# CITY OF ALBUQUERQUE

April 10, 2012

**Re: APS Community Sports Stadium, Conceptual Grading and Drainage Plan,  
(J08/D002) Parcel C-1, Westland North, Engineer Stamp Date 3/12/2012**

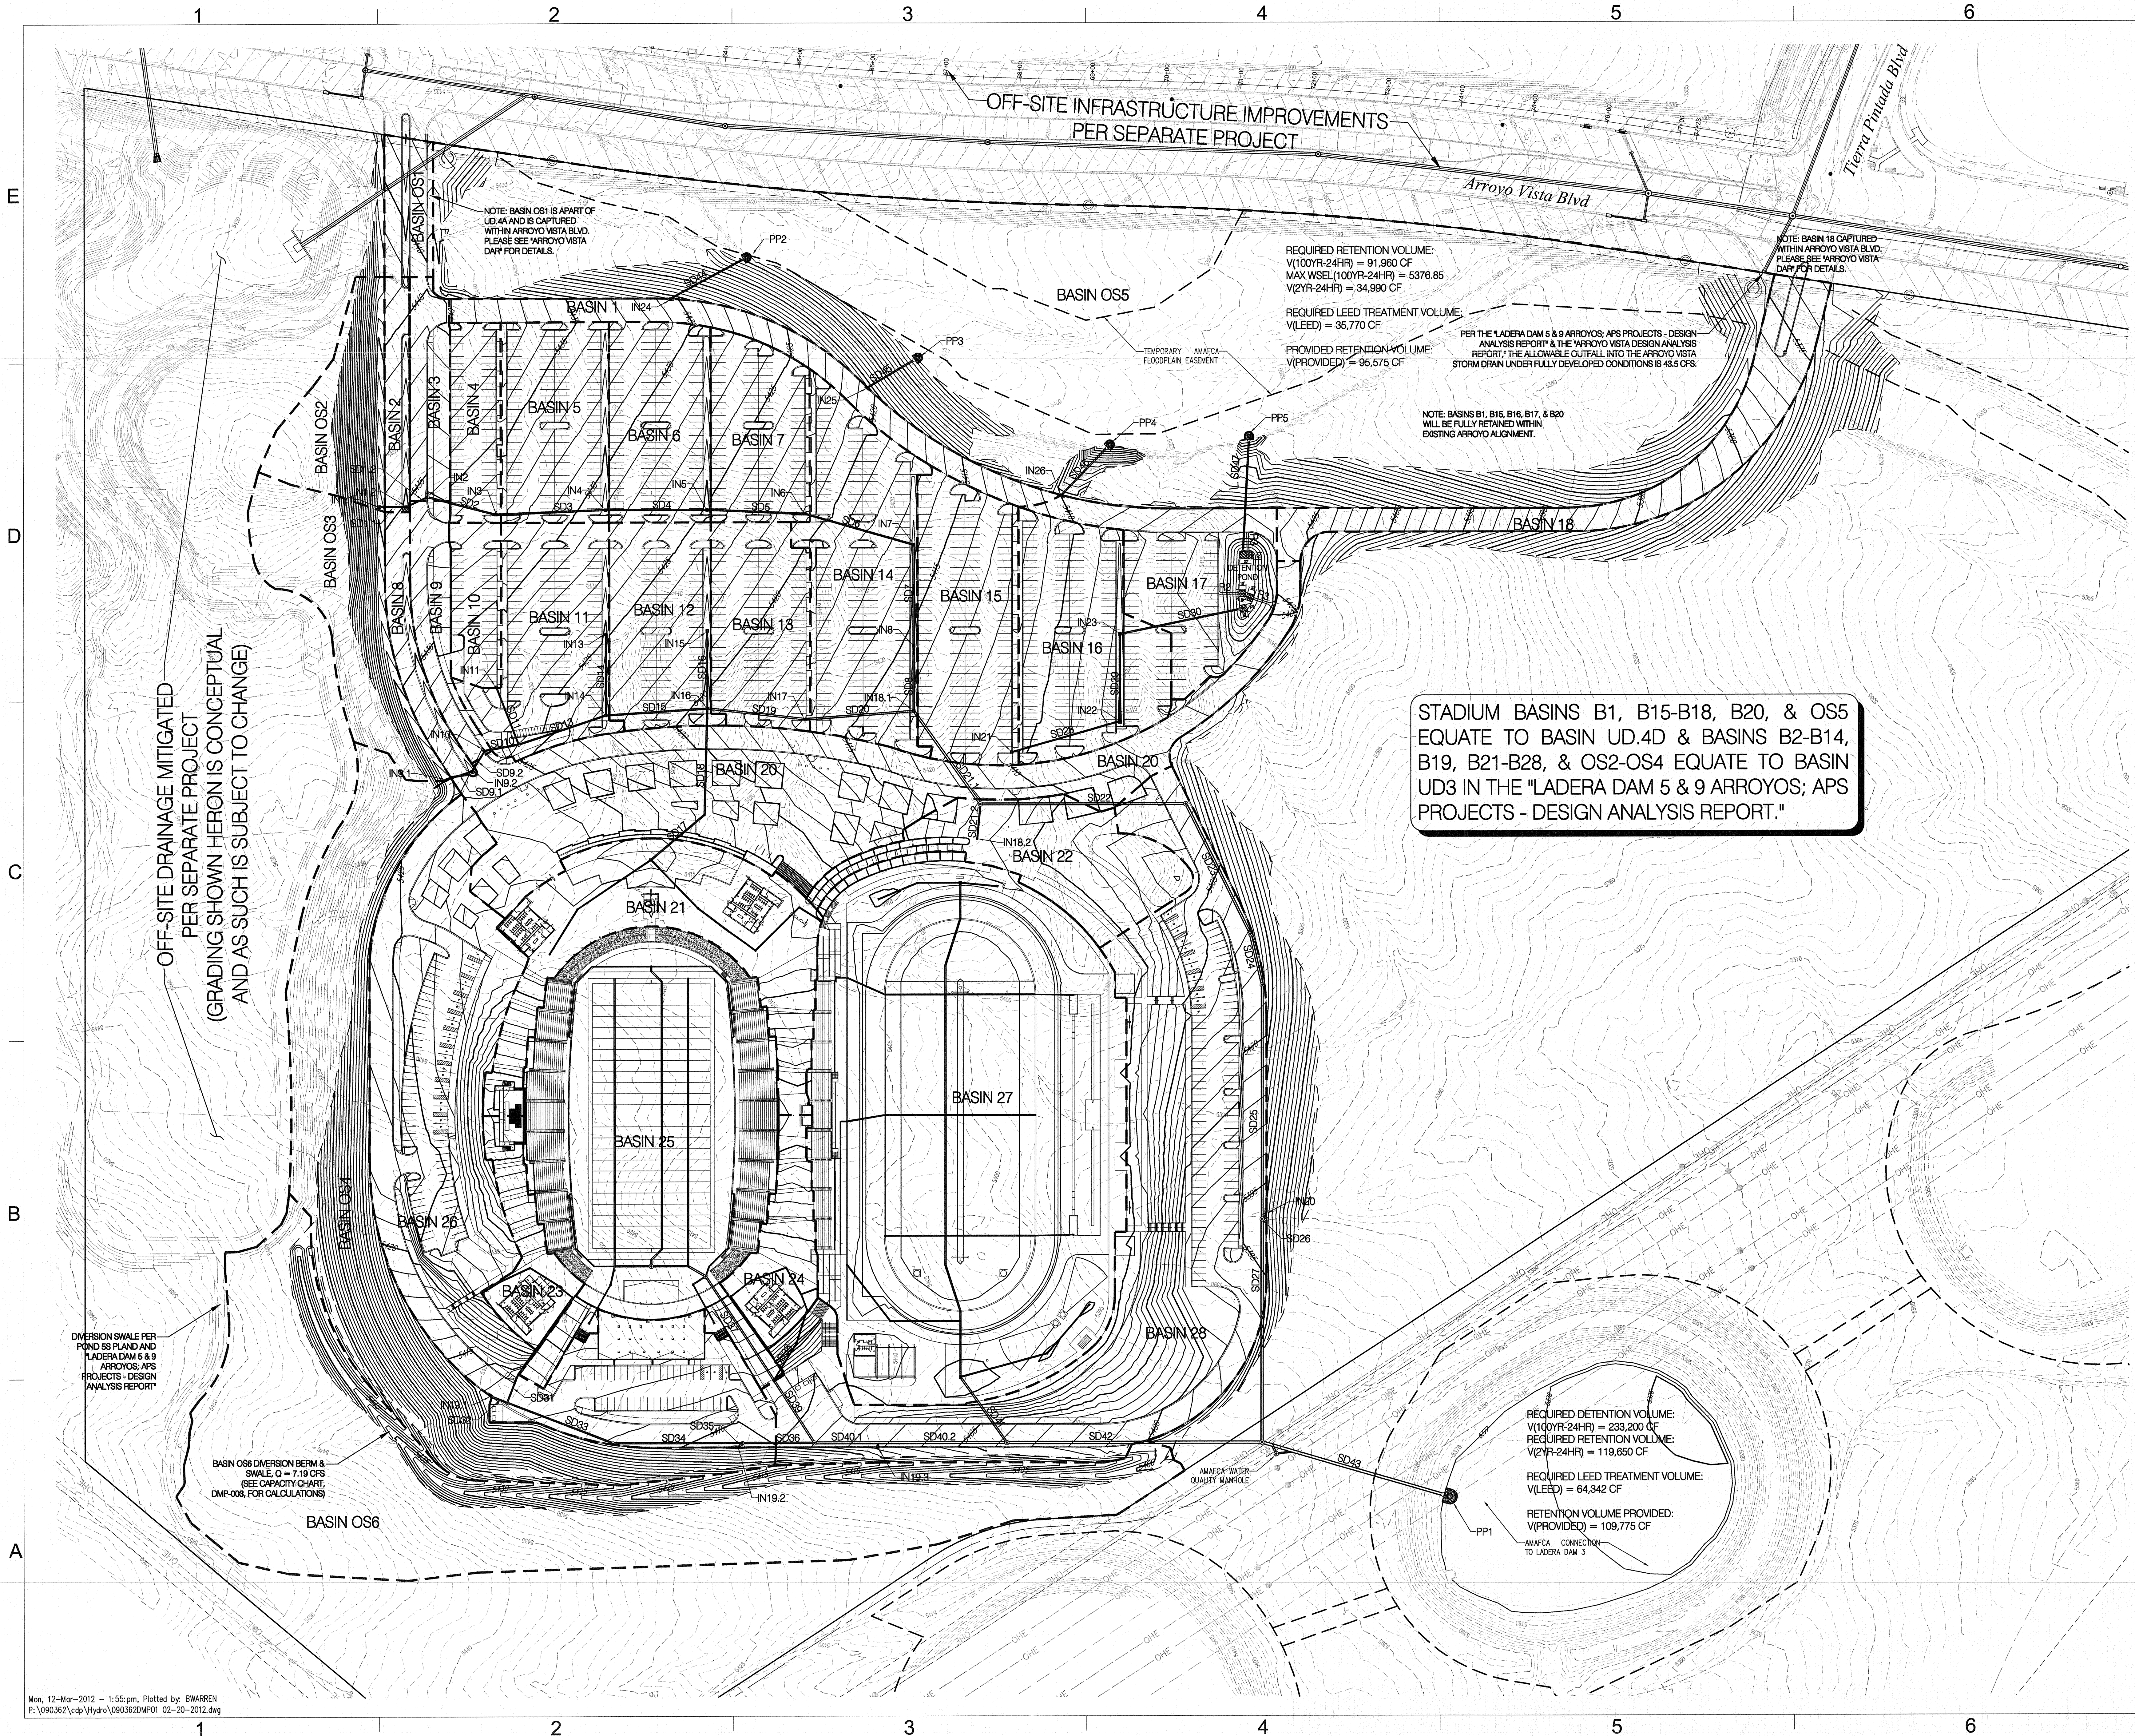
- Portion of Basin 22 appears to overflow to Basin 28.
- Recorded Easement will be required for the storm drain pipes SD27, SD42, and SD43 for the portion that is outside the APS property.
- Encroachment agreement with PNM for the construction of the storm drains through their easement.
- Encroachment agreement with AMAFCA.
- Pond 5S and outflow pipe have to be constructed and certified.
- Proposed construction under the City of Albuquerque work order number 650274 must be constructed and accepted by the City of Albuquerque.
